Letter of Intent for Application for Special Use Permit

Monument Glamping El Paso County, Colorado

PCD File No. AL-22-003
Originally Prepared: March 16, 2022
Review Addenda: May 9, 2022

MONUMENT GLAMPING SITE PLAN
16315 RICKENBACKER AVE.
MONUMENT, CO 80132

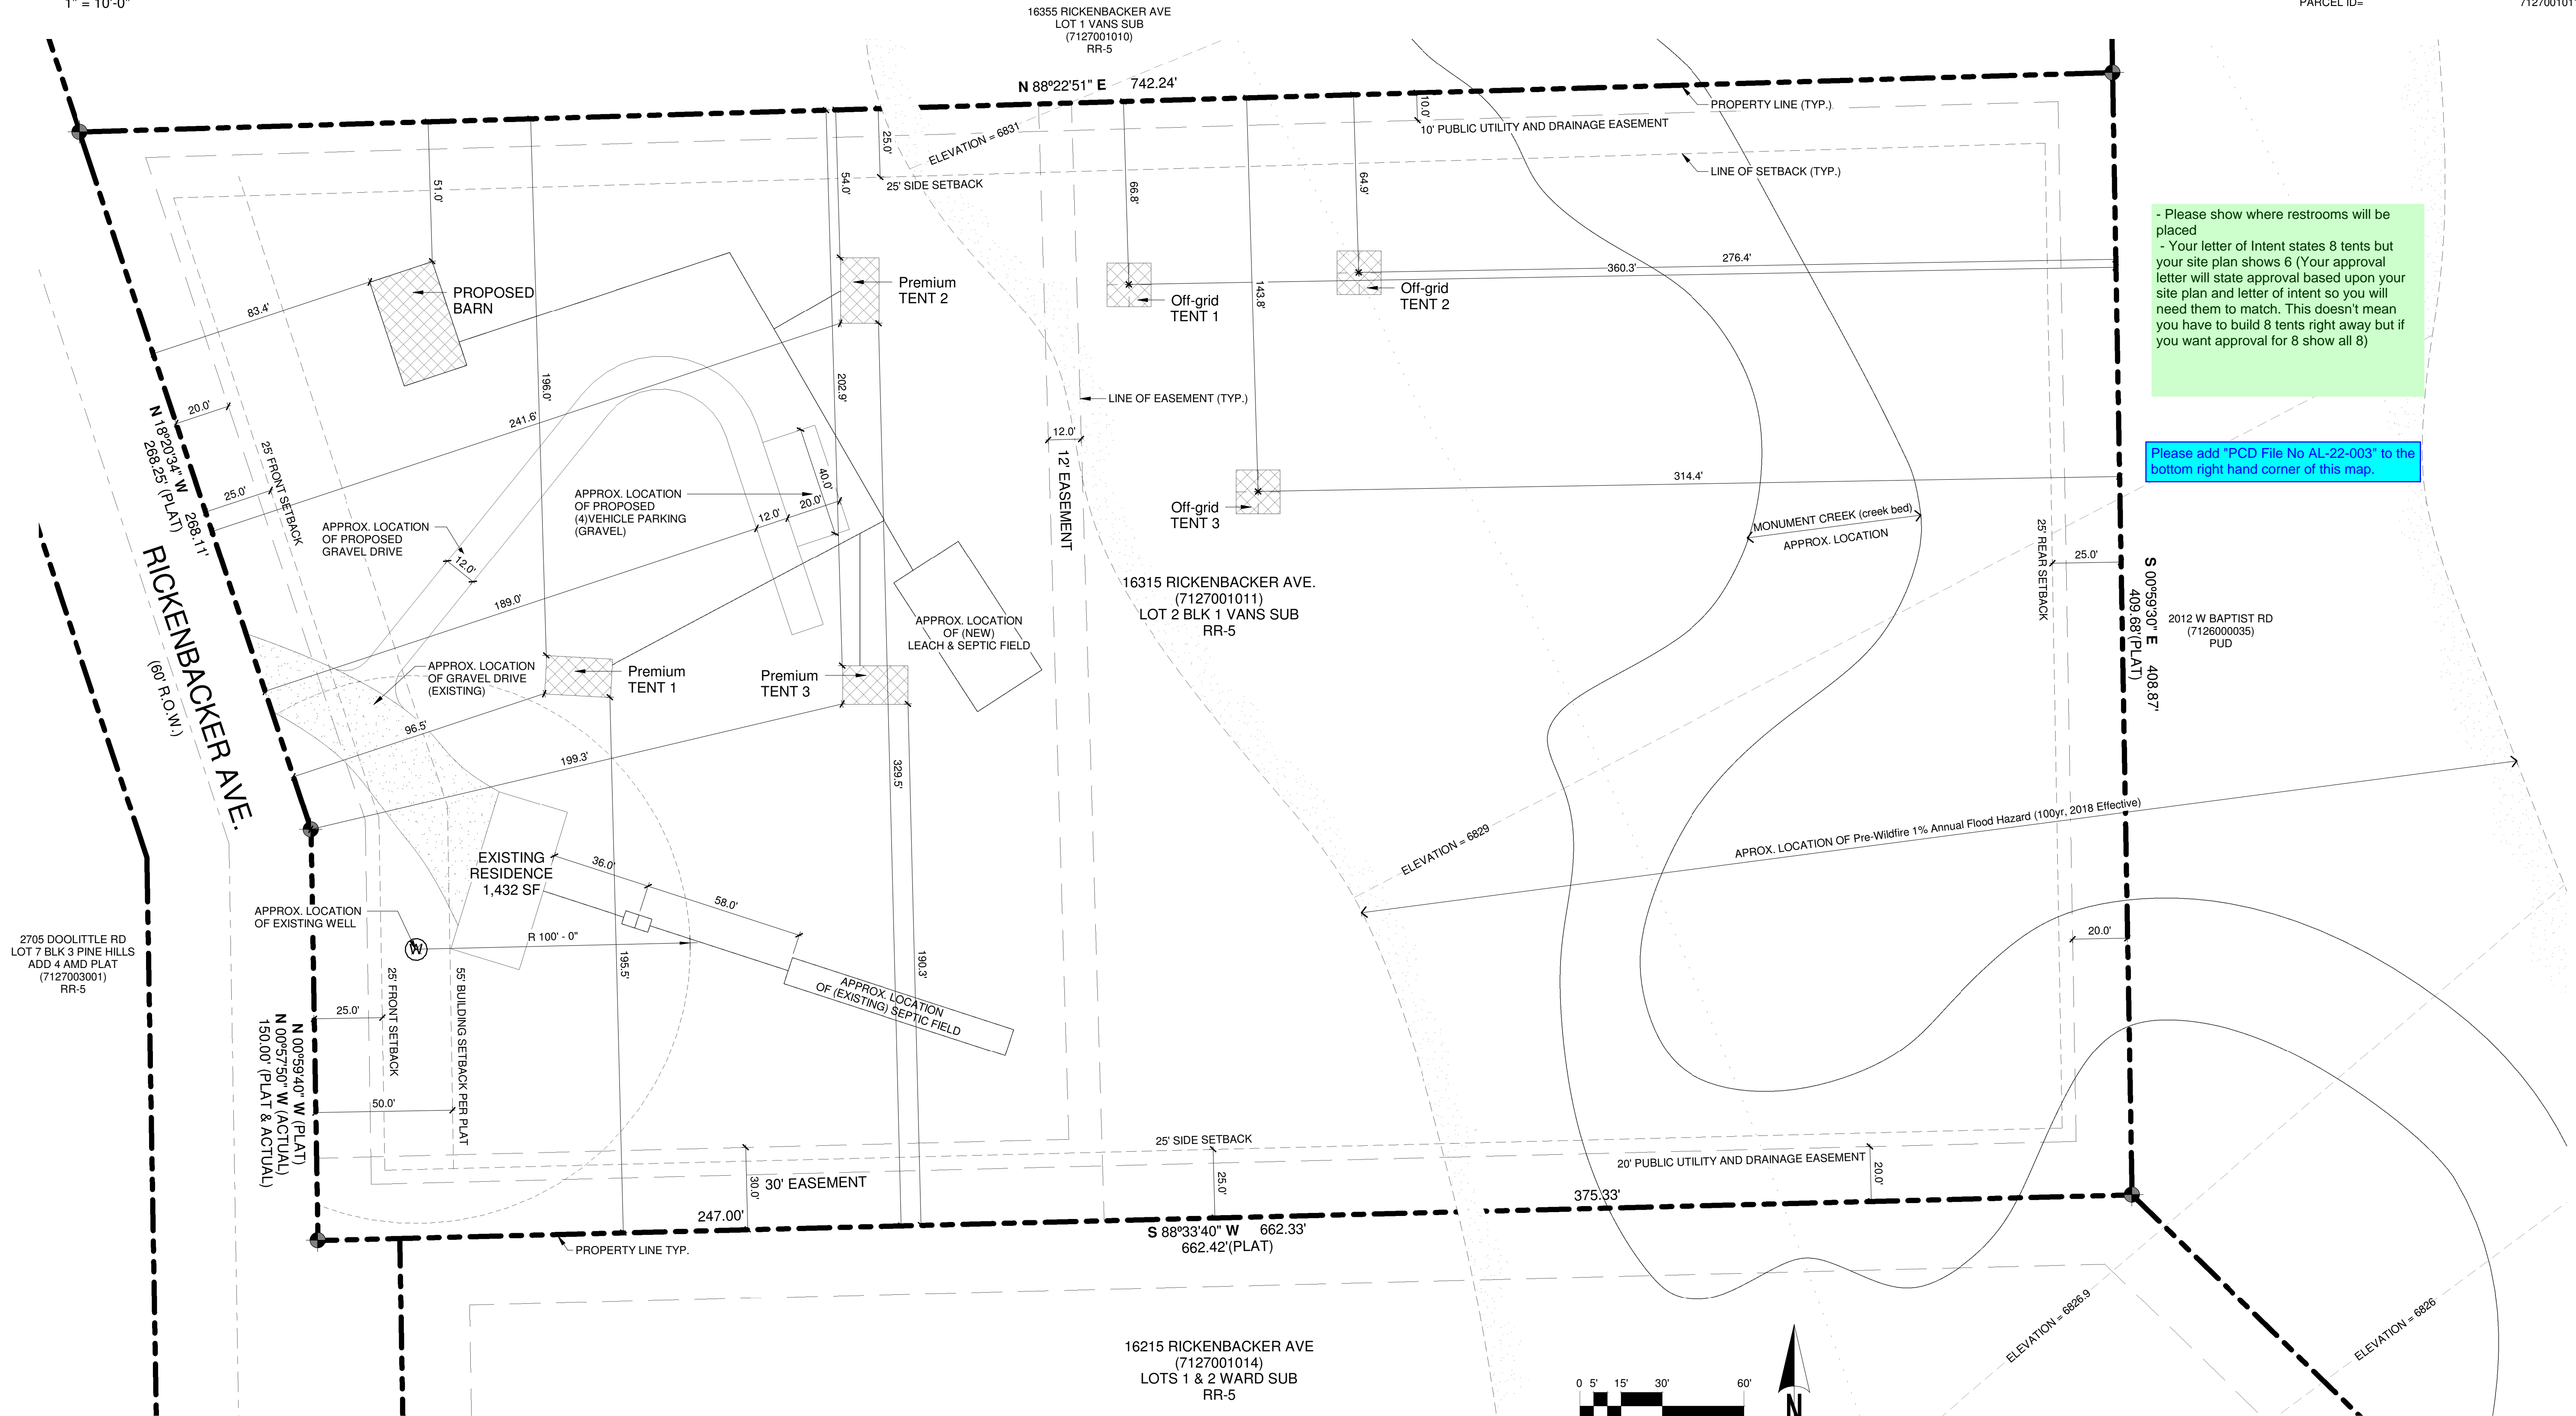
Your site plan depicts 6 tents are you asking for 8?

Explain how each site will have its own bathroom. Is it in the tent?

Please show all requested units on your site plan.

You only show 4 parking stalls on site, where will the other 4 cars park if you have all 8 tents occupied? Update site plan to reflect parking

Addended 5/5/22 for clarity after meeting with a neighbor: For the sake of this development, our glamping "units" will consist of "premium" sites and "off-grid" sites. For the sake of this Special Use, every "unit" is recognized as a single dwelling unit with water and septic limitations as engineered by code. This Special Use is capped at 8 units (the maximum dwellings allowed with the new septic system), and our Site Development is building only 6 units (3 premium sites and 3 off-grid sites).
